From: Brian Banister
Sent: 23 September 2008 12:28
To: Planning.Responses
Subject: RE: Planning Consultation on: PA/21/08/

APPLICATION NO: PA/21/08/

Registered: 15-SEP-08
Site Address: Robinswood The Street Patching

Description of Works: Infilling the carport to provide a garden room and the erection of a new single storey extension comprising double garage, new front entrance door, sitting/study area, cloakroom and an ensuite guest bedroom. Removal of the concrete tile hanging to the first floor of the existing house and replacement with external insulation and timber cladding.

0616 SK18
Robinswood House
Proposed Elevations 1 of 2
July 2008
Scale 1:100

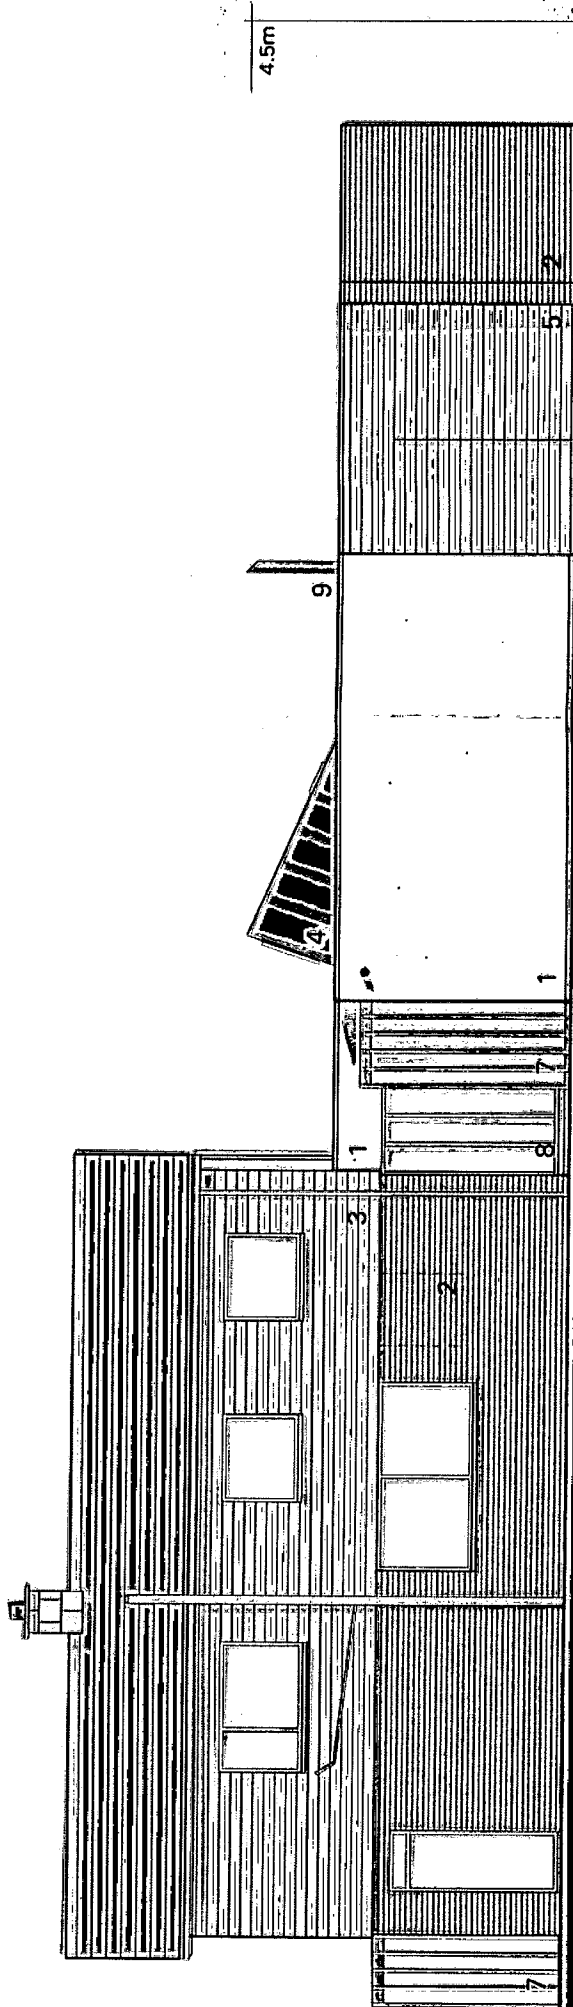
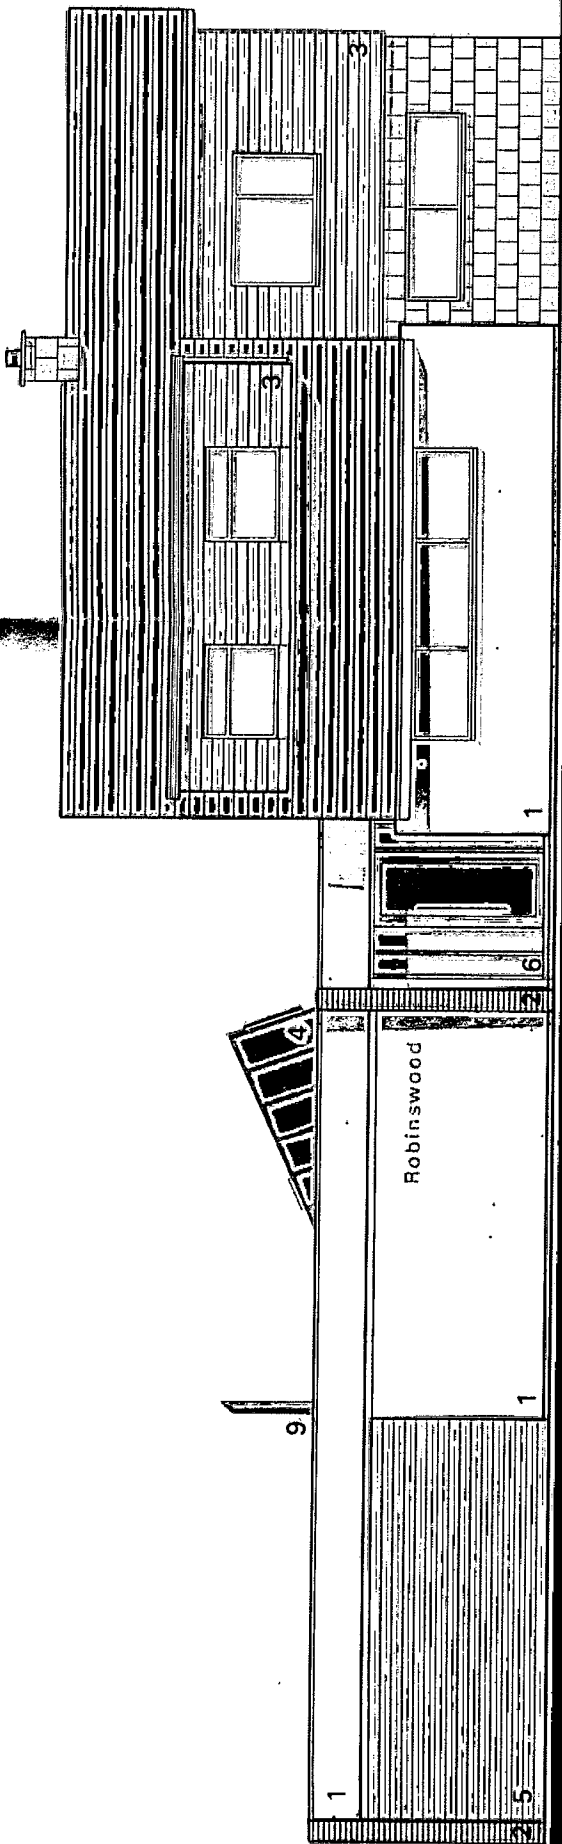
It is not possible to properly assess this without detailed elevational drawings. I seem to recall that this is a wooded site where you may have to assess the effect of any extension on nearby trees.
